**CITY OF ALBUQUERQUE
PLANNING DEPARTMENT
February 26, 2014
DRB Comments**

PROJECT # 1009924

**RE: Tract 126-A Conservancy Map #34, AND Lot P,
Alvarado Gardens Addition Unit 2**

**PLAT OF  
LOTS P-1, P-2 AND P-3  
ALVARADO GARDENS ADDITION, UNIT 2**

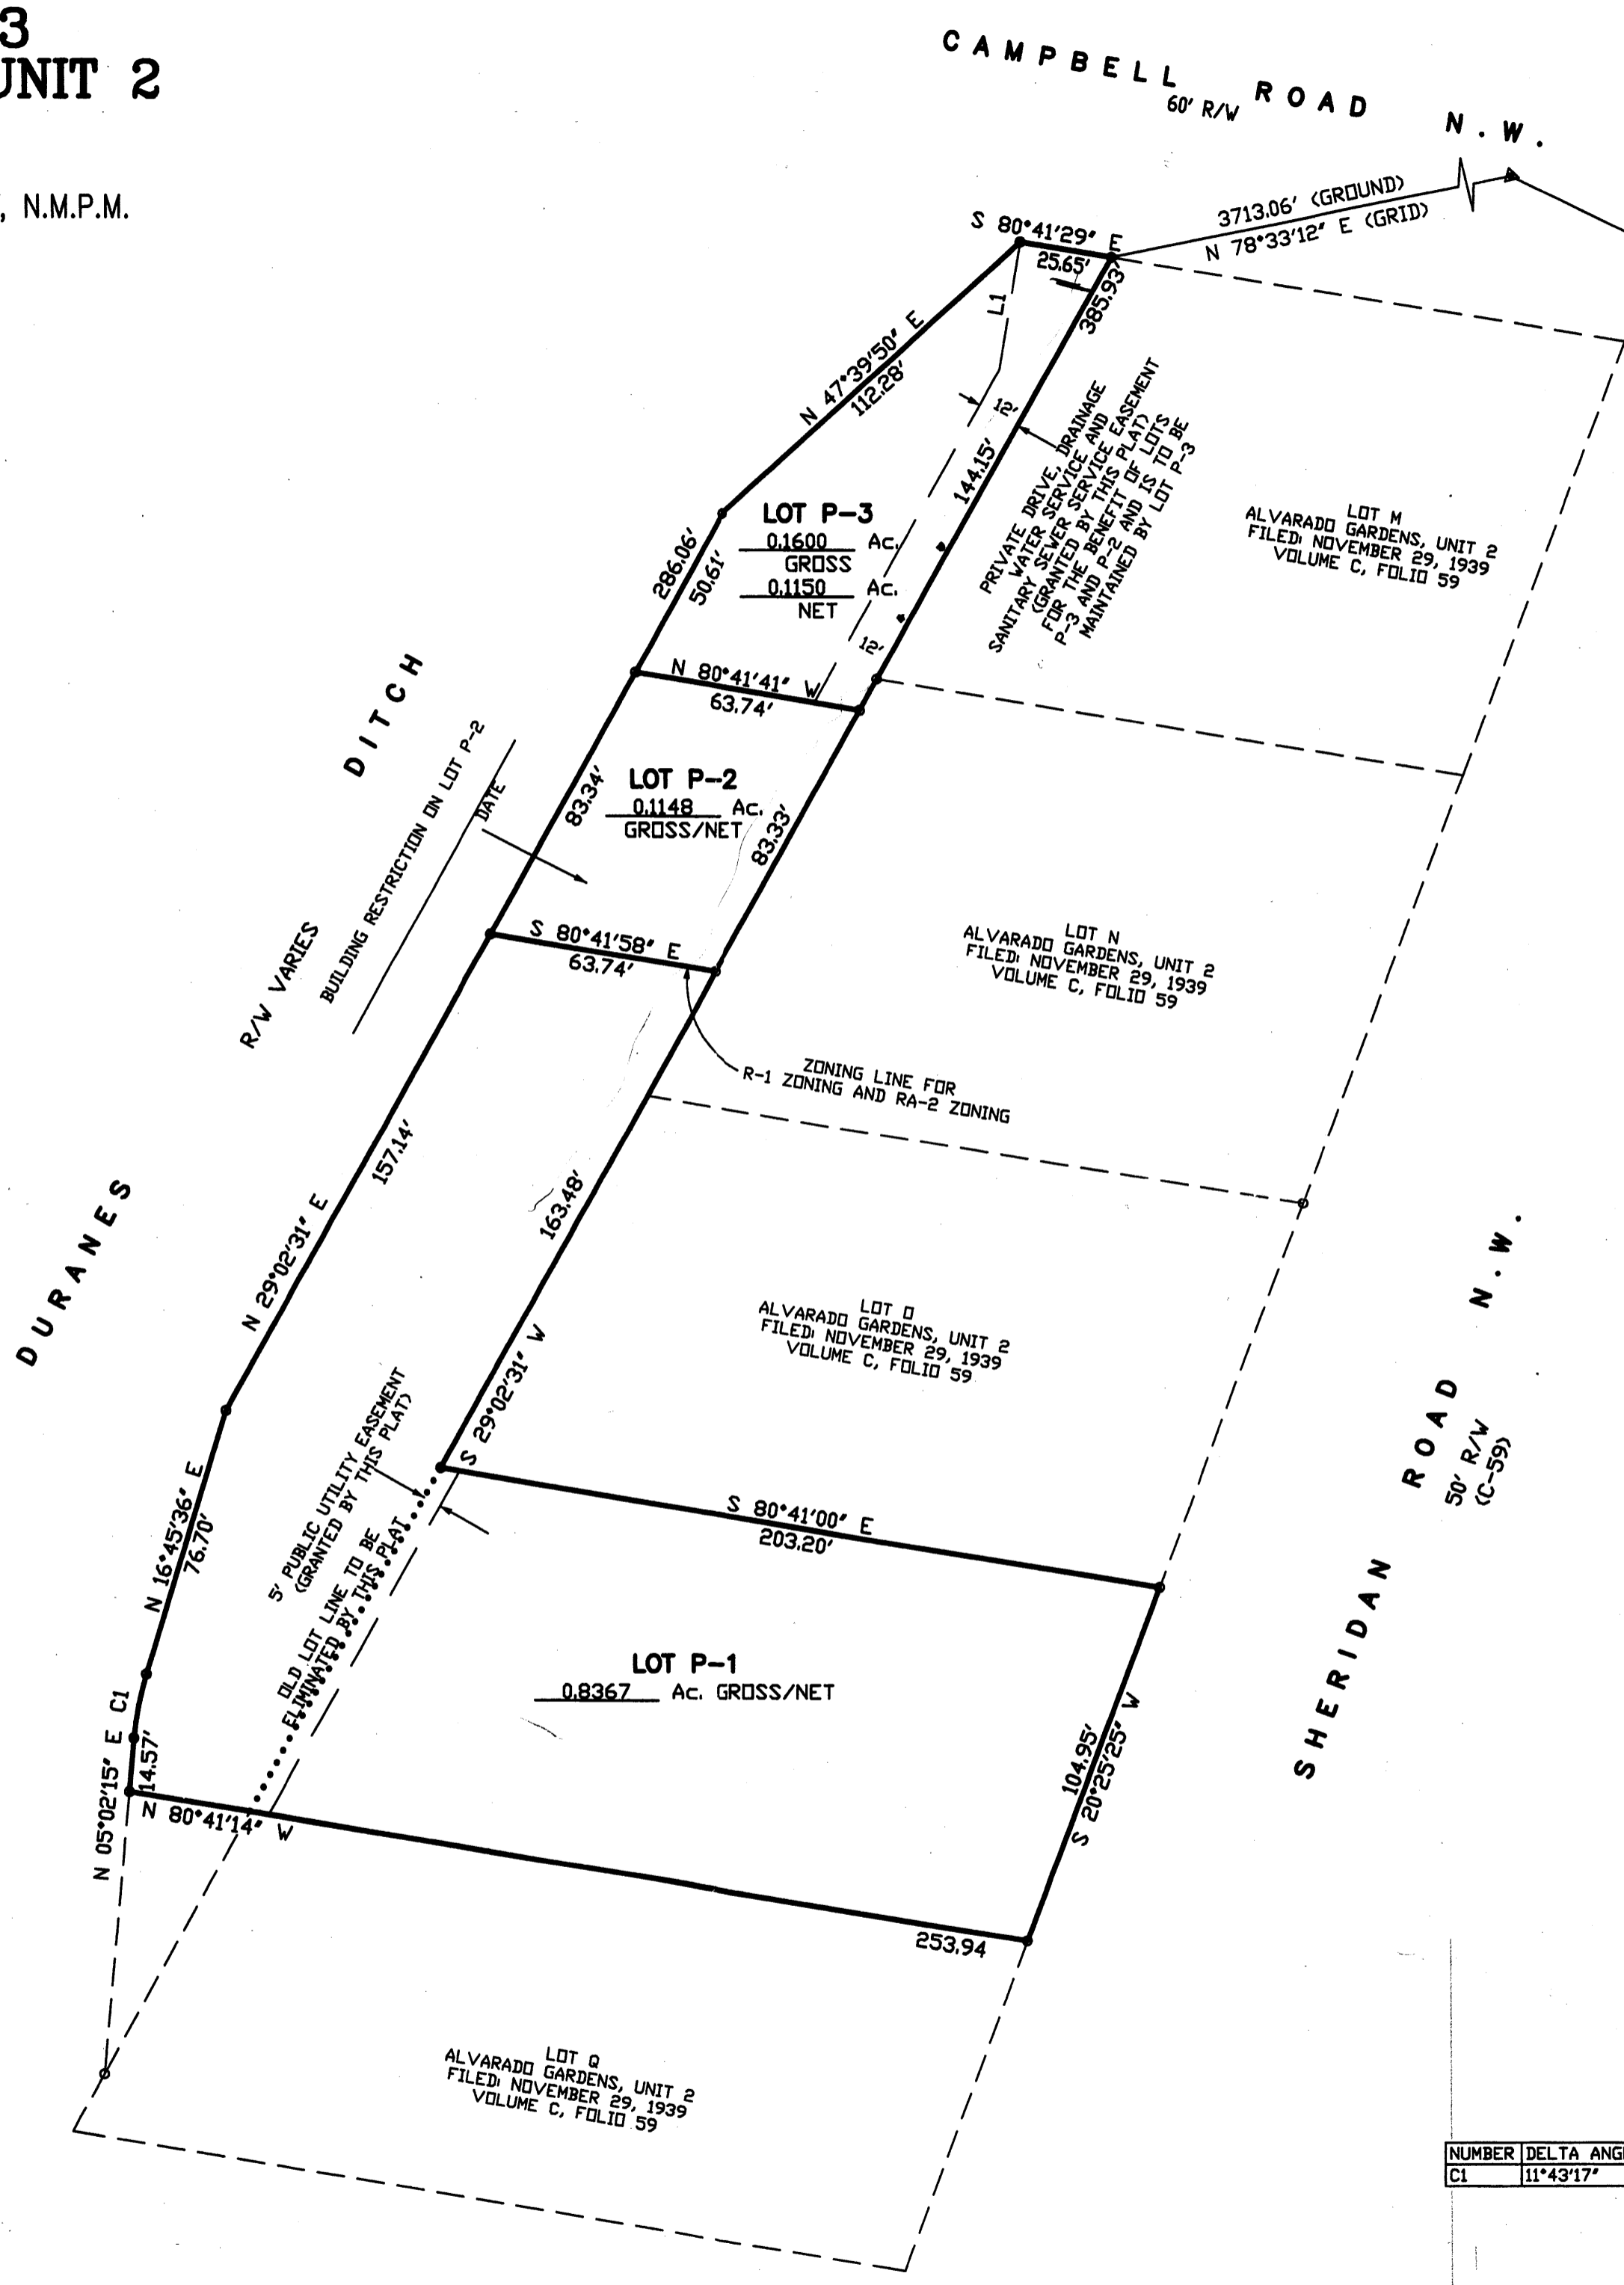
✓ The leader for the "ZONING LINE etc." note does not correctly point to the boundary of the different zones on proposed Lot P1, which is the 'OLD LOT LINE.' The note should be revised to simply read "ZONE BOUNDARY" and point to where the two lots are being joined.

There are utility lines down the eastern edge of proposed Lot P-3, P-2 etc. and a utility pole within the proposed access easement; a utility easement is needed, and the access easement or the utility pole need to be adjusted.

**PLAT OF  
LOTS N-1, N-2, P-1 AND P-2  
ALVARADO GARDENS ADDITION, UNIT 2**

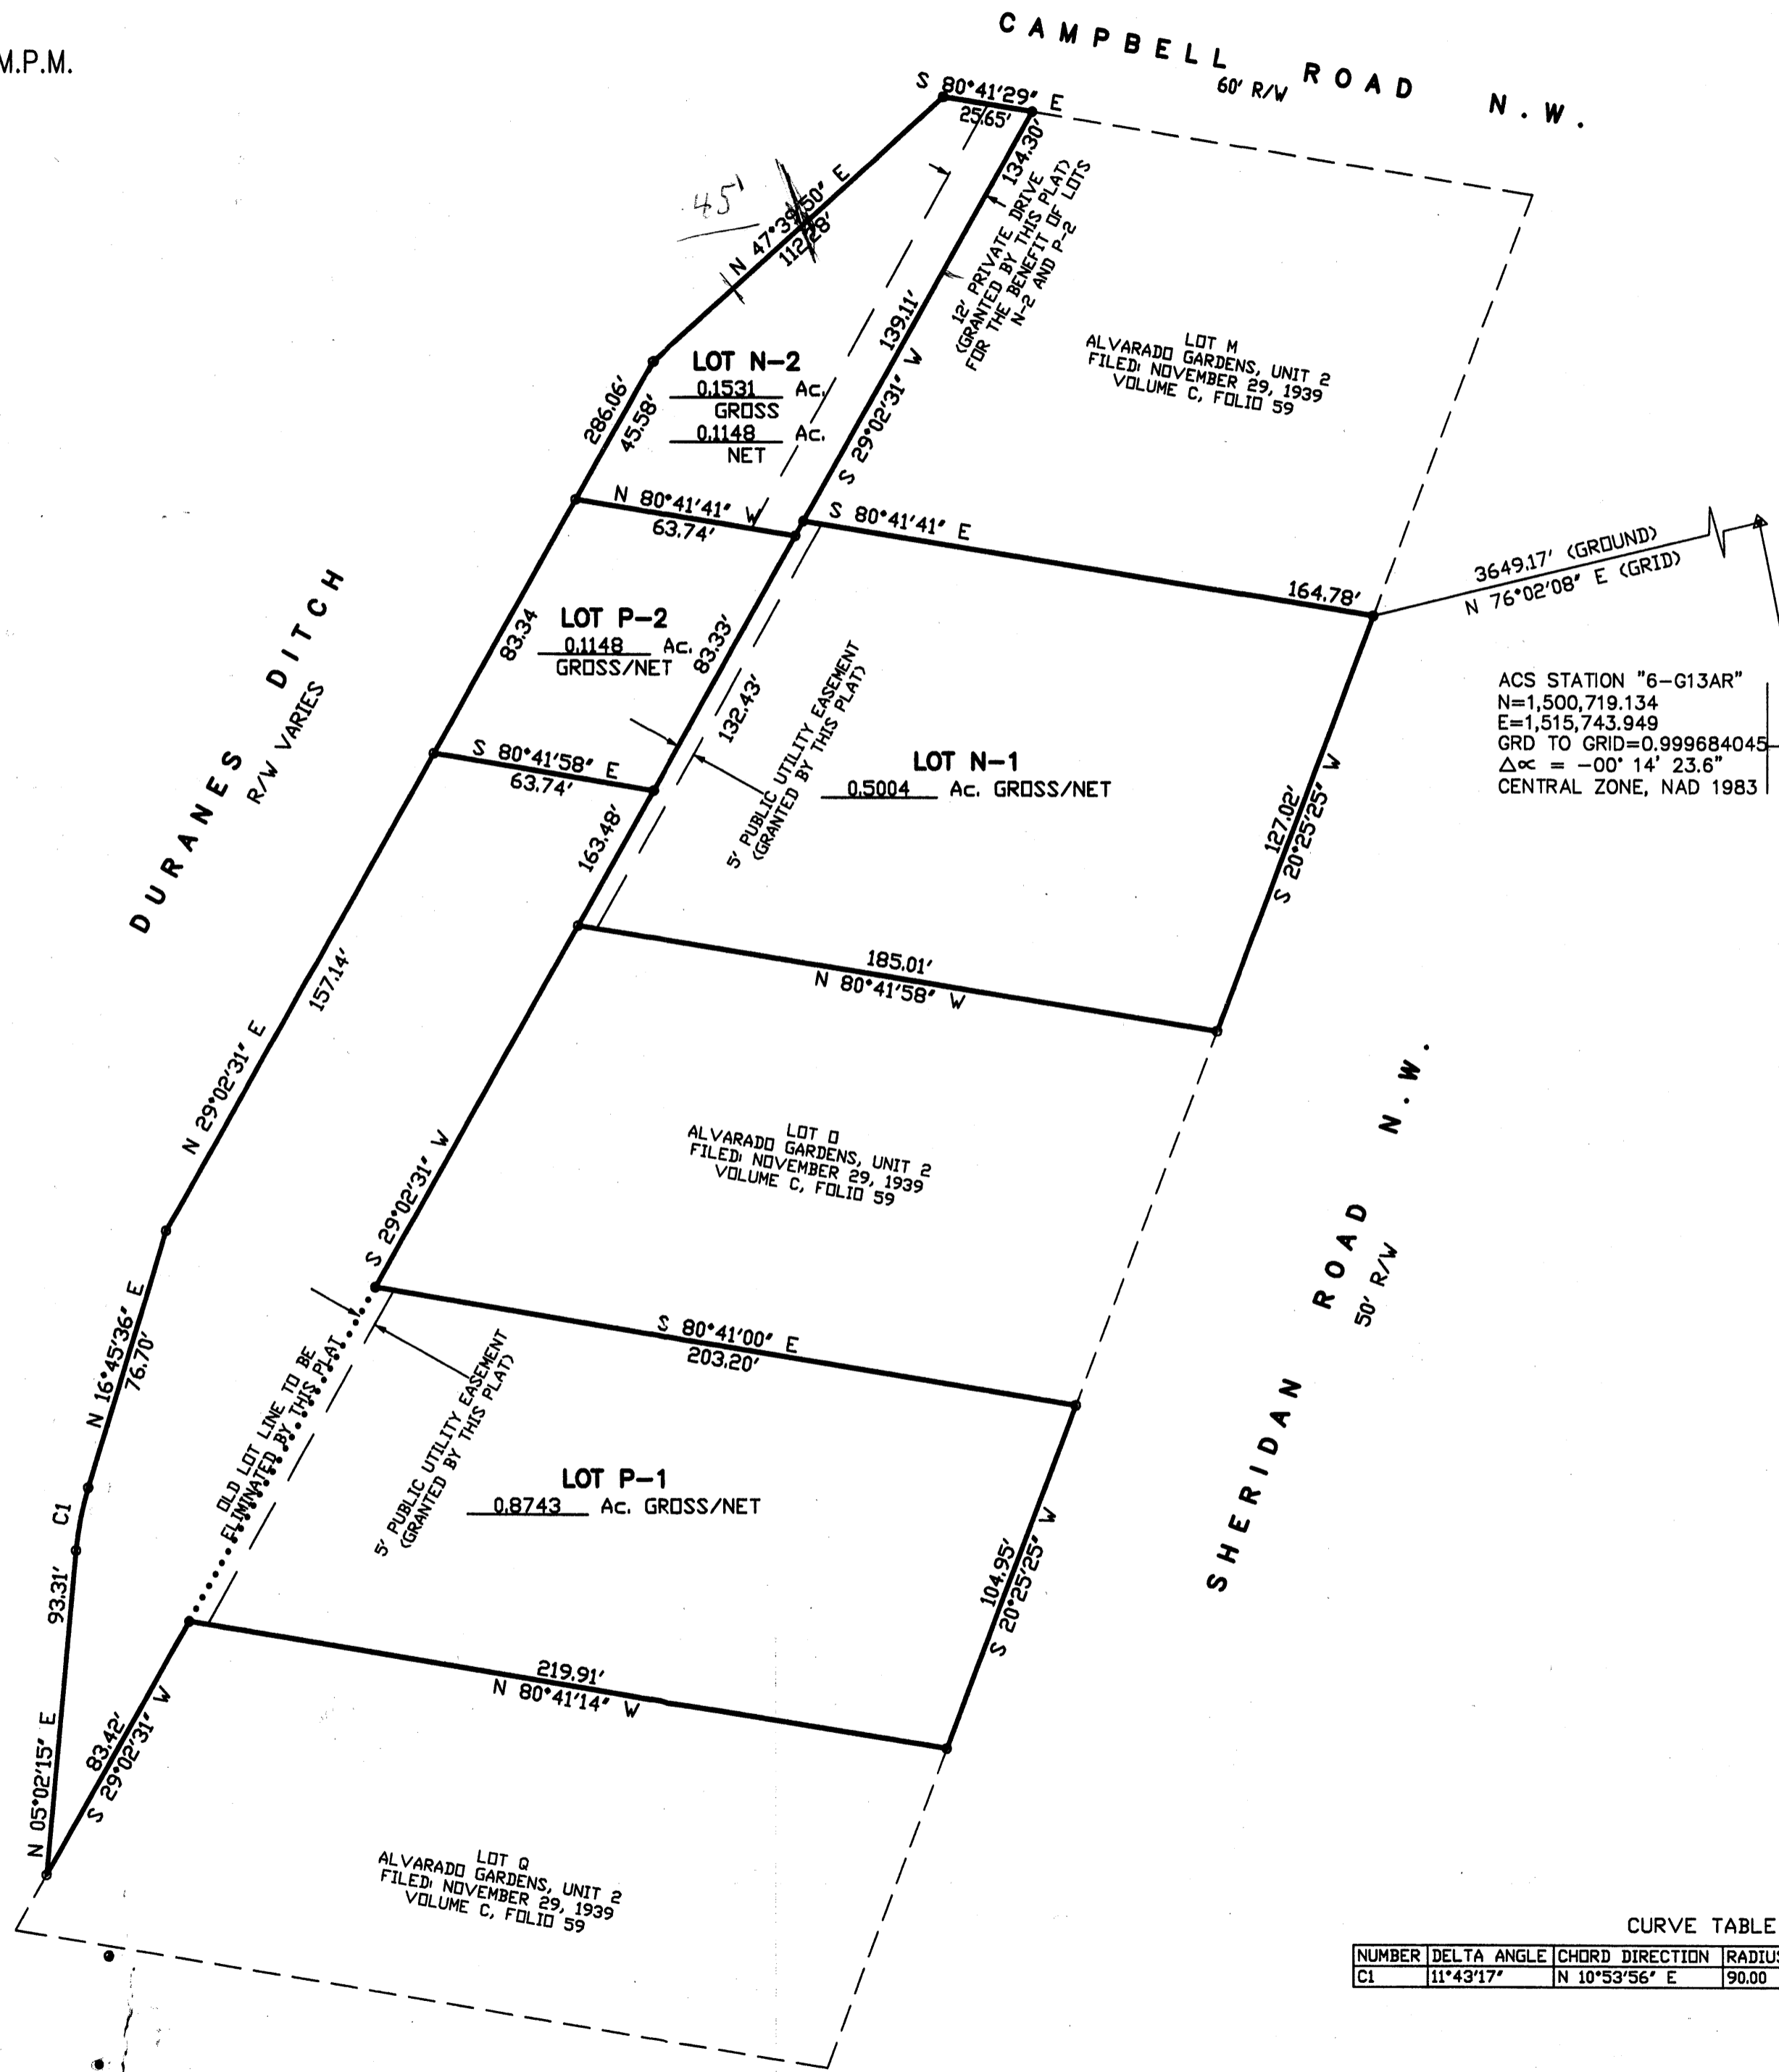
A leader is needed for the "ZONING LINE etc." note to point to the boundary of the different zones on proposed Lot P1, or the note could be relocated to coincide with the 'OLD LOT LINE' designation – as shown, it cannot be determined whether the 'Zoning Line' continues on the labeled bearing or follows the lot line(s). Per previous comments, a simple "ZONE BOUNDARY" designation would be sufficient (and preferable).

Also per previous comments, the platting appears to include TR 126-B which is shown by the County Assessor to be owned with adjacent Lot Q; title documentation/ Assessor clarification is needed.

The proposed 'PRIVATE DRIVE, etc.' needs to be labelled as an EASEMENT and maintenance responsibilities need to be clearly noted on the plat.

Minimum lot size on the R-1 portion of the plat would be 6,000 sq ft NET unless a lot size variance is approved by the ZHE, or if it can be documented that the proposed 5,000 sq ft lots would not depart from a pattern of larger developed lots which constitutes the established low density/ RA-2 character of the Campbell Road neighborhood. Please note that the property to the west is a Private Commons Development of 14 lots on 4 acres, wherein all of the area gained through lot sizes under 10,640 sq ft was required to be set aside in a pattern of Private Common Areas to maintain the low density character of the neighborhood.

The 2 other existing lots are zoned RA-2 and per the Zoning Code, the boundary of a zone is a lot line unless clearly otherwise shown; a line identified as “ZONE BOUNDARY” is needed on proposed Lot P-1 to allow AGIS to clearly identify the different zones. The platting appears to include TR 126-B which is shown by the County Assessor to be owned with adjacent Lot Q.

The proposed ‘Private Drive’ needs to conform to the minimum requirements of Table 23.2.2 of the DPM, which will require an Infrastructure List; additionally this ‘drive’ needs to be labelled as “PRIVATE ACCESS/ WATER SERVICE/ SANITARY SEWER SERVICE EASEMENT” and maintenance responsibilities need to be clearly noted on the plat.

Minimum lot size on the R-1 portion of the plat would be 6,000 sq ft NET unless it can be demonstrated that 5,000 sq ft lots would not depart from a pattern of larger developed lots which constitutes the established character of the neighborhood, otherwise a lot size variance would be required. Please note that the property to the west is a PCD of 14 lots on 4 acres. Additionally, it appears a lot width variance will be needed regardless of applicable lot size.
